Lead Local Flood Authority

Date 14th July 2026

RE: WA/18/26/PL - Land off Arundel Road Fontwell

We **maintain our objection** to this application, and require additional information:

Drainage Plans and Calculations

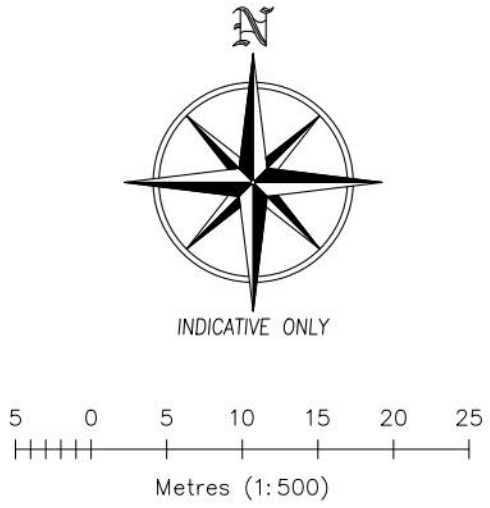
While infiltration is not being used to drain the site, there are several instances where the drainage strategy implies infiltration is still being used. For example, paragraphs 1.3.23 and 1.3.34 and the Contributing Areas Plan and Drainage Strategy Plan all still mention infiltration or infiltration basin. This does not accurately reflect how the site is proposed to drain. There may be other instances where this is an issue. It is also important that this is reflected in any other relevant document submitted under this application, to ensure documents are consistent.

The infiltration basin is still included in the Contributing Areas plan.

While a swale is mentioned in para 1.3.20 to 1.3.21, it is not included in the Drainage Strategy Plan or calculations.

It is unclear whether the design of the attenuation basin has considered the high groundwater levels. We request a cross section of the basin and porous paving, to ensure groundwater is considered in the design of SuDS features.

This is not adequately addressed. Currently, the cross section shows that the base of the basin is where the highest groundwater level is located. There does not appear to be any evidence of how the groundwater has been considered in the design of the basin. It is important the capacity of the basin is not impacted by high groundwater levels, as flood risk could increase elsewhere.

In addition, the permeable paving cross section is missing.

It is unclear whether freeboard from the 1 in 100 year plus climate change event has been included in the basin design.

A minimum 3m easement for the attenuation basin is required, for maintenance access.

The easement shall go around the entire basin, rather than part of it. In particular for the side near the building, it is unclear whether the basin can be safely maintained.
